FIVE ESTUARIES OFFSHORE WIND FARM DEVELOPMENT CONSENT ORDER

PINS REFERENCE EN010115

**DEADLINE 5: PORT OF LONDON
AUTHORITY'S COMMENTS ON SUBMISSIONS
RECEIVED AT DEADLINE 4**

Figure 2.1: Overview of area of interest for NIP.

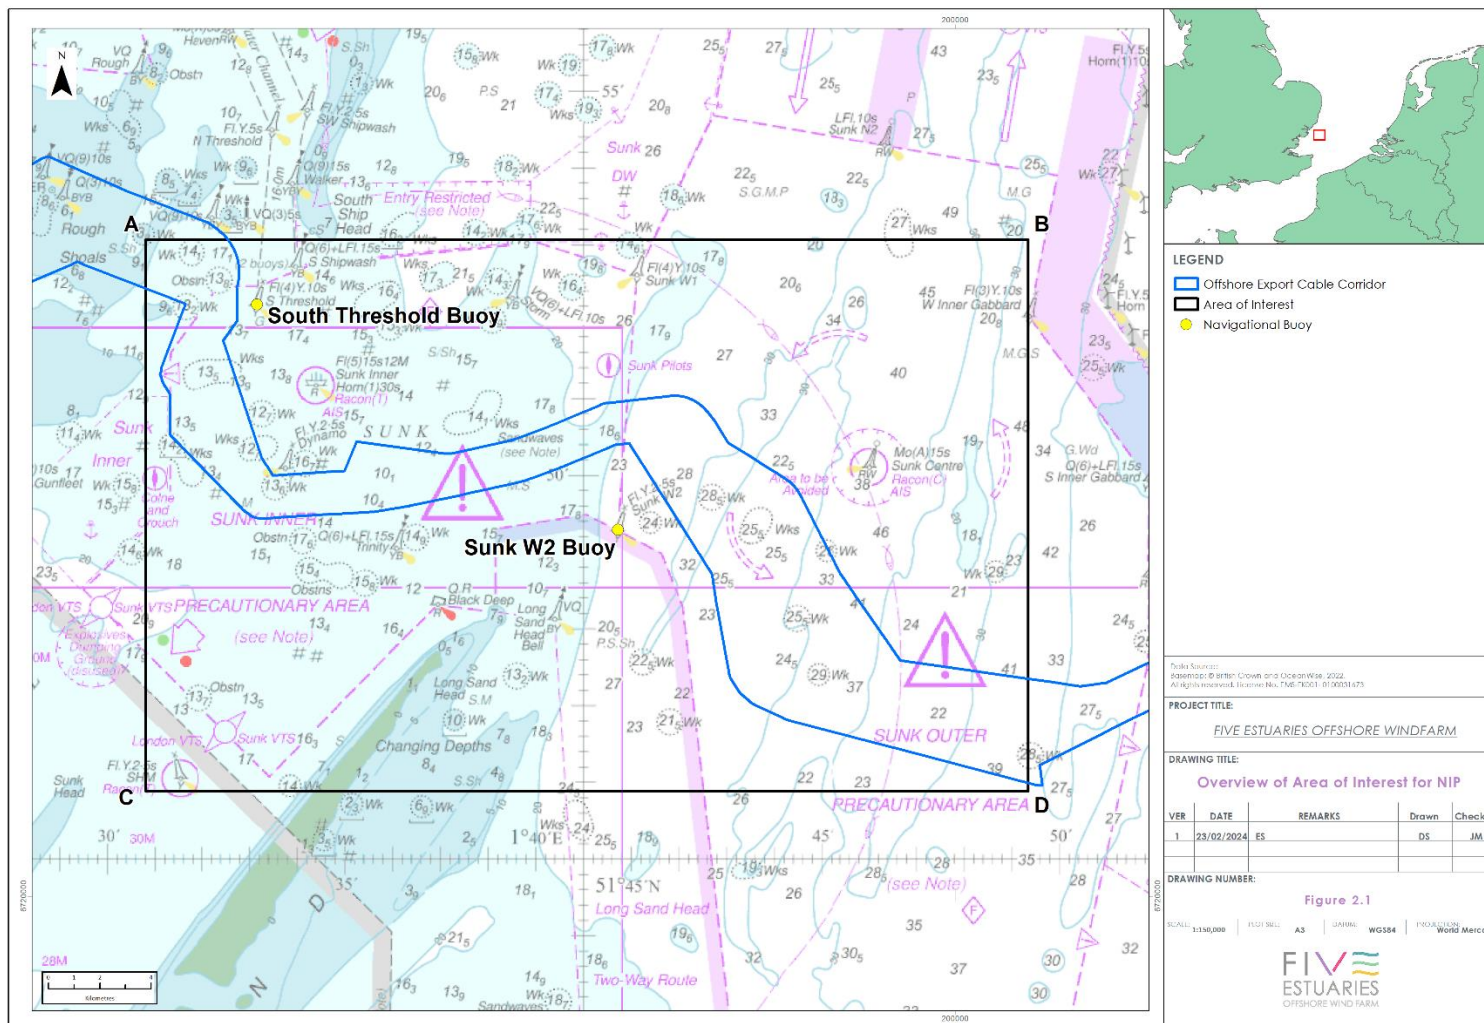
- 2.5 It is also unclear who, if anyone, would approve any updates to the NIP. These are clearly contemplated by the Applicant – see for example section 2.6 of the oNIP [REP1-040] but the oNIP is quiet on the submission of updated plans to the MMO for approval simply stating interested parties will be invited to review and discuss any changes, and the updated NIP will then be promulgated to relevant third parties.

- 2.6 The NiP also does not appear to apply to pre-construction activities with paragraph 2.3.1 of the oNIP stating *“The NIP will apply from the start of offshore construction activities.”* This means that activities such as pre-construction surveys would not be covered by the oNIP with table 3.1 advising that the vessels ability to manoeuvre during a pre-construction survey is to be confirmed and surveys may be taking place within the DWR's. The PLA considers that either the NiP needs to include pre-construction activities, or the PLA must have approval of these activities through its protective provisions.

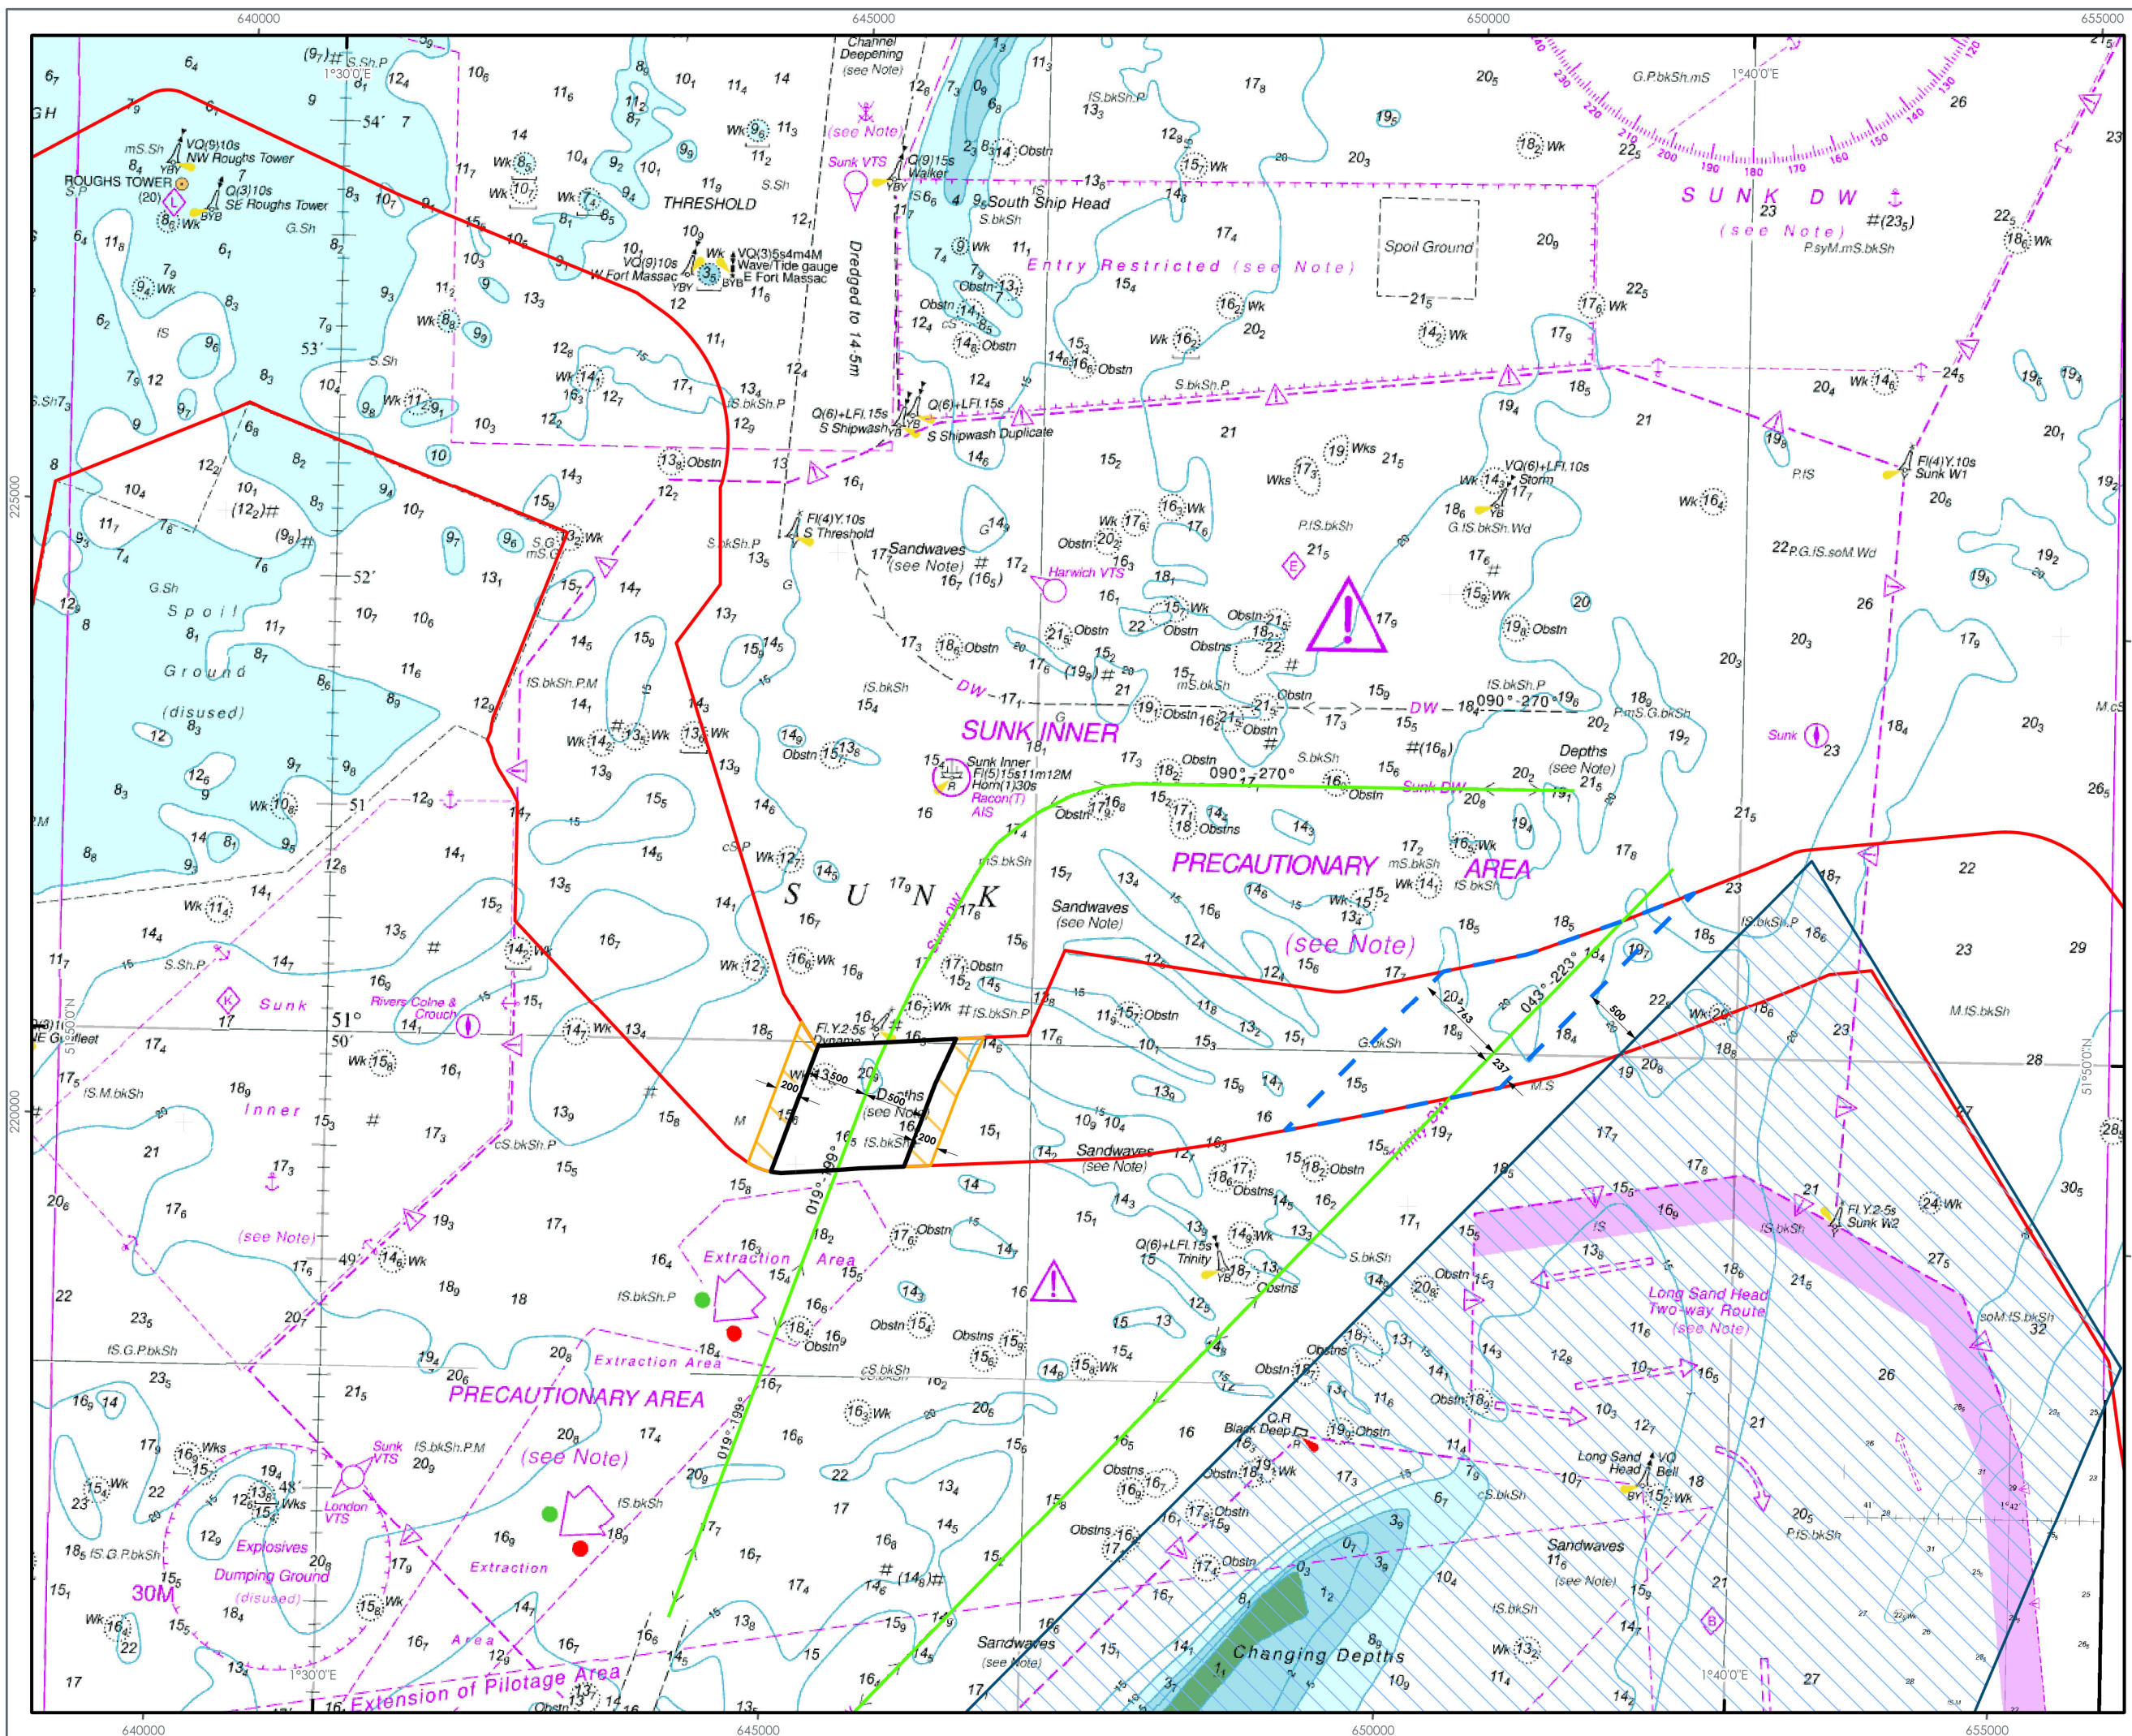
- (a) The definition of "*Deep Water Route (DWR) areas*" should be widened to include the full suite of commitments that relate to the DWRs. The PLA suggests (addition text in bold) "*Areas within the ECC relating to the Sunk and Trinity DWRs as shown in Figure 2.1 where specific commitments are defined in relation to matters including cable installation and maintenance, boulder clearance, archaeological finds, disposal of dredge material, cable crossings and cable jointing.*"

- (e) Table 1 – It is recommended that the Shipping and Navigation entries are split so it is clearer where the mitigation relates to the DWRs part of the ECC and where it relates to the area of the ECC that does not include the DWRs. As an example, Shipping and Navigation entry 1 refers to use of the DWRs not being compromised but then talks about reduction in water depths of no more than 5%

- (f) Table 1 – new shipping and navigation entry "*Impacts to the future use of case of the DWR's*" should be amended to read "*Impacts to the future use of the DWRs*" and the mitigation section should be updated to make it clear that cable installation and maintenance will be at a sufficient depth to allow the DWRs to be dredged to 22m below CD. As drafted, the entry gives the impression that the cables could be installed at 22m below Chart Datum and if this was to occur it would prevent the DWR's from being

dredged to the required depth. The text advises that boulders and archaeological finds will not be relocated within the DWR. In line with the commitment elsewhere in the document, the table should be clear that crossings with known projects will not occur in the DWRs; planned field joints will not occur in the DWR's and sediment disposal will not occur within or within a zone where disposal could reasonably impact the DWRs. The fourth column of the table should be updated as necessary in line with the updates to column three.
